**Consultation Response from: KC Environmental Health (Pollution & Noise Control)**

**2024/93605 Land at Main Avenue, Cowlersley, Huddersfield, HD4 5US**

**Erection of 57 dwellings with access from new through road connecting Main Avenue and Windsor Road, and associated works, including engineering and landscaping**

**Responding Date:**  
**6<sup>th</sup> June 2025**

Client	Project	Scale
STRATA HOMES	MAIN AVENUE, KIRKLEES	1:1000 @ A3
	Title	Date
A3	006 - TOPSOIL ZONING PLAN	JUNE 2024

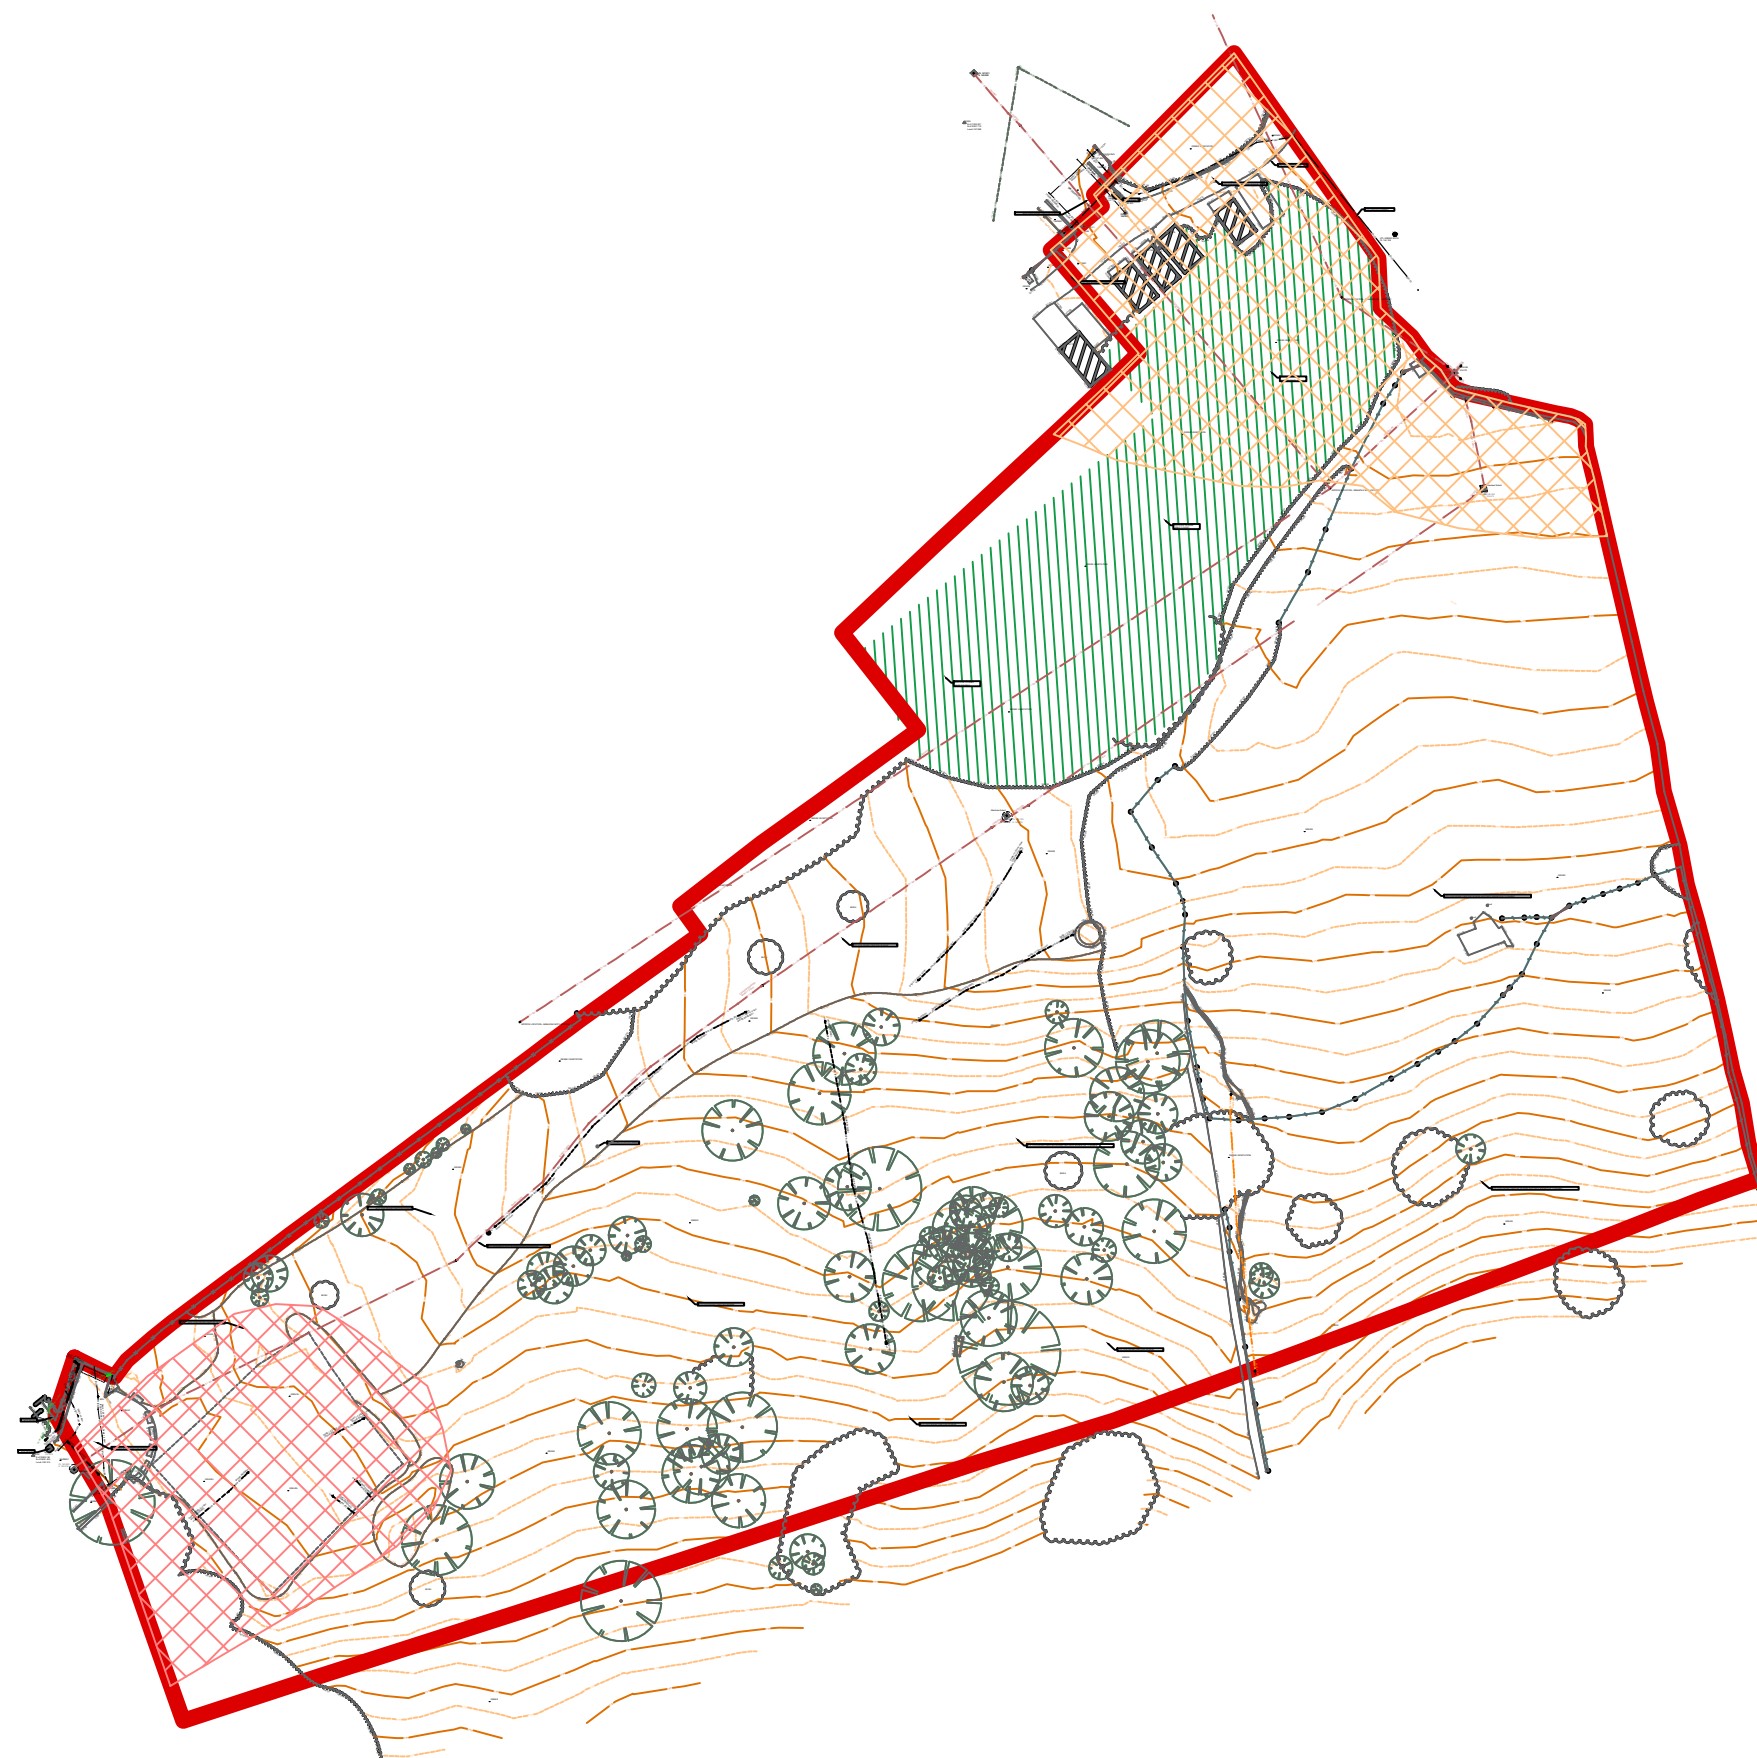
Additional we note the topsoil at TP104 (main site) appears to contain arsenic levels above the screening value used throughout the Apex Investigations, therefore we would question the reuse of topsoil in this area and consider additional clarification/commentary is necessary.
